From: Laura Gibbons
Sent: 24 June 2019 09:48
To: Planning.Responses <Planning.Responses@arun.gov.uk>
Cc: Amber Willard <Amber.Willard@arun.gov.uk>
Subject: RE: Planning Consultation on: WA/49/19/HH

Engineers Comments Regarding Surface Water Drainage

APPLICATION WA/49/19/HH

Description of Works: Replacement of two flat roofs with pitched roofs
and cladding to the upper elevations including
juliette balcony to north elevation.

Roof Works and cladding Proposed Roof Plan and Sections

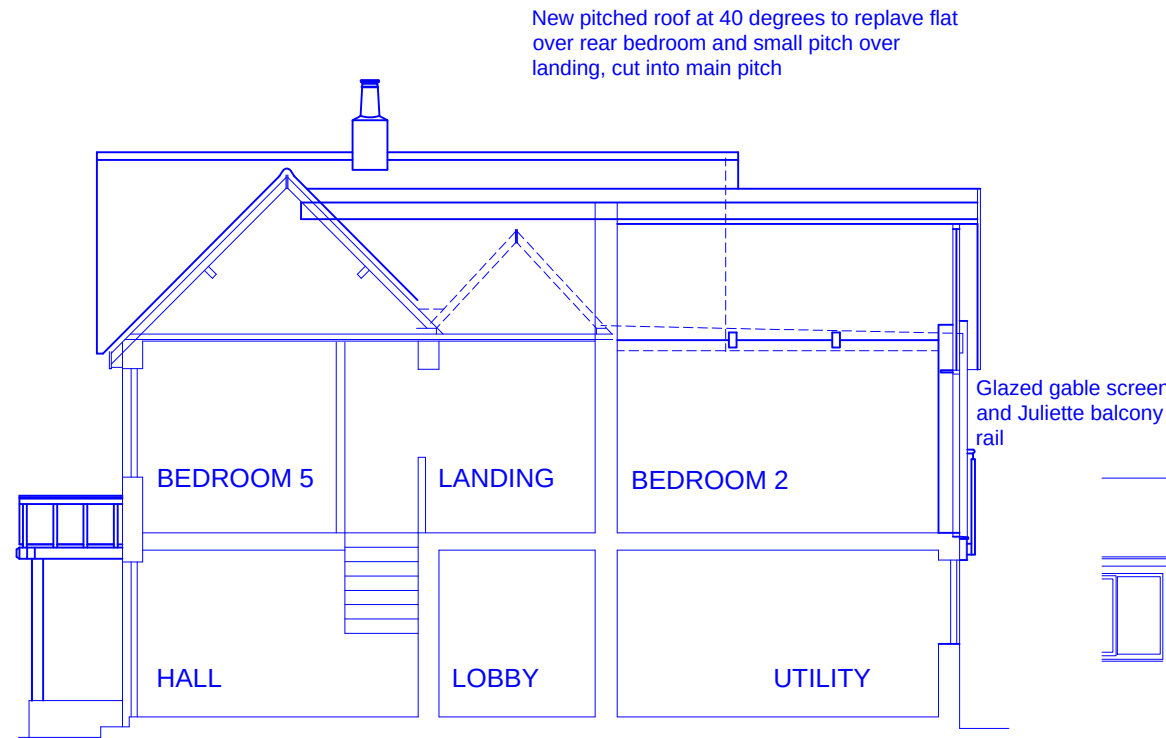
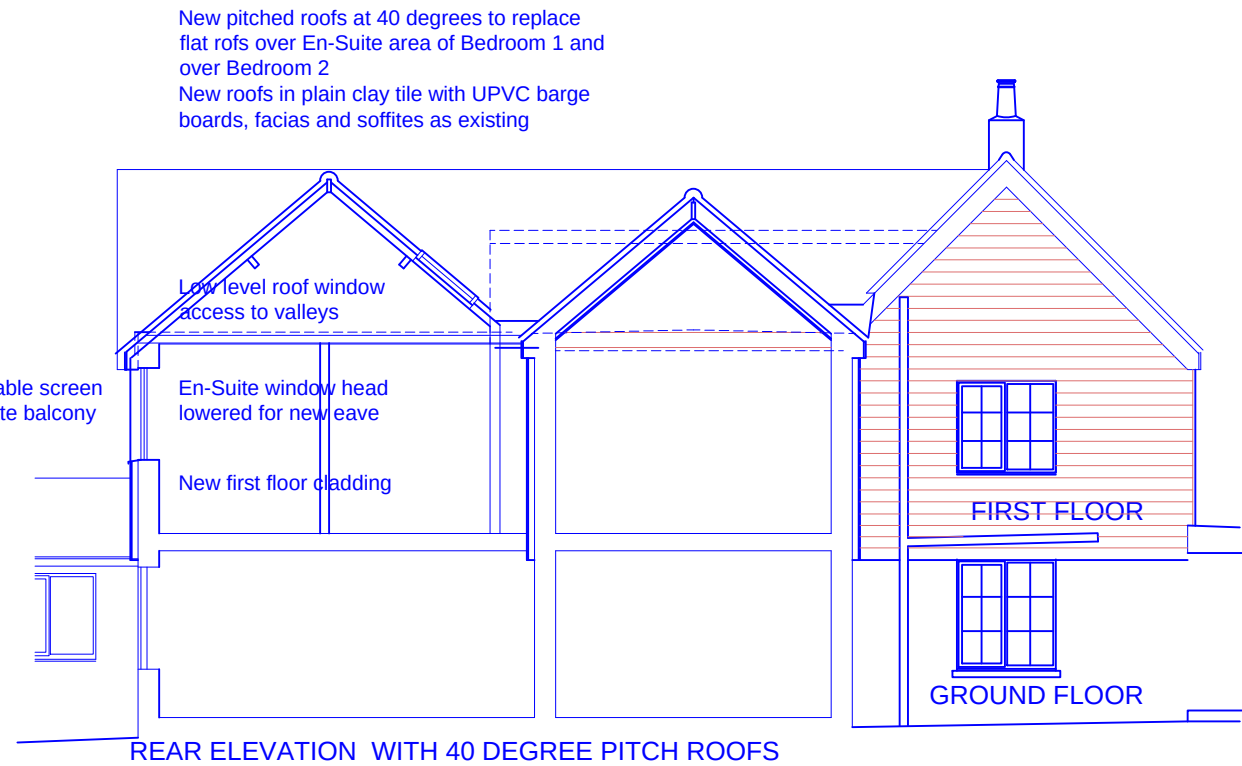
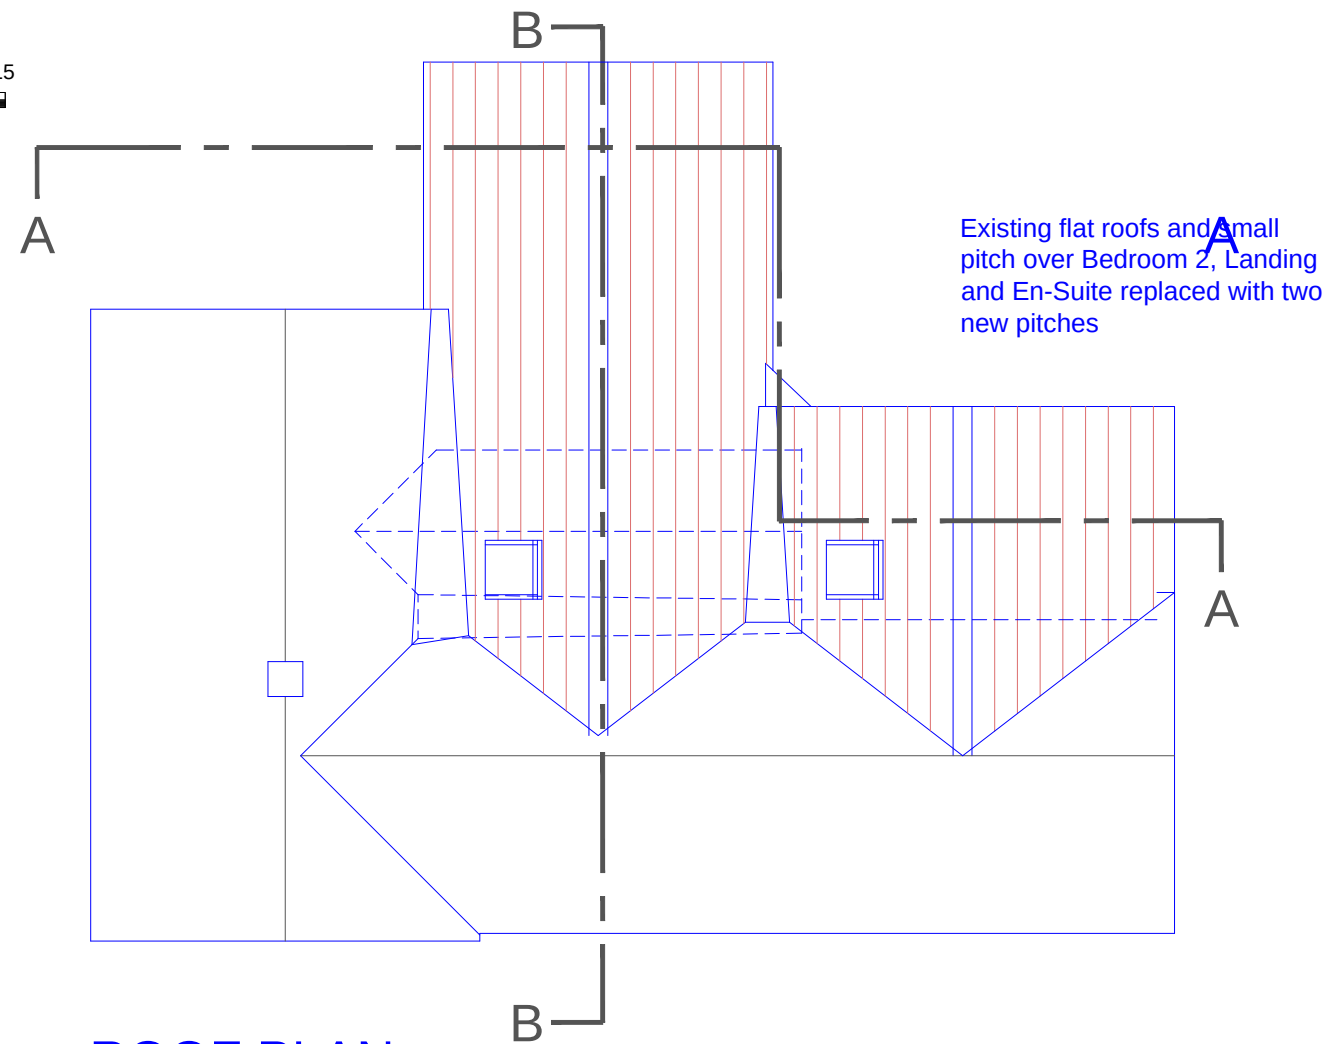
The application is for a change in roof from flat to pitched, this will speed up the conveyance of rain water. The application is within the Lidsey catchment and therefore surface water drainage design should be carefully considered. Infiltration must be fully investigated.

"Development shall not commence, other than works of site survey and investigation, until full details of the proposed surface water drainage scheme have been submitted to and approved in writing by the Local Planning Authority. The design should follow the hierarchy of preference for different types of surface water drainage disposal systems as set out in Approved Document H of the Building Regulations, and the recommendations of the SuDS Manual produced by CIRIA. Winter groundwater monitoring to establish highest annual ground water levels and winter Percolation testing to BRE 365, or similar approved, will be required to support the design of any Infiltration drainage. No building / No part of the extended building shall be occupied until the complete surface water drainage system serving the property has been implemented in accordance with the agreed details and the details so agreed shall be maintained in good working order in perpetuity."
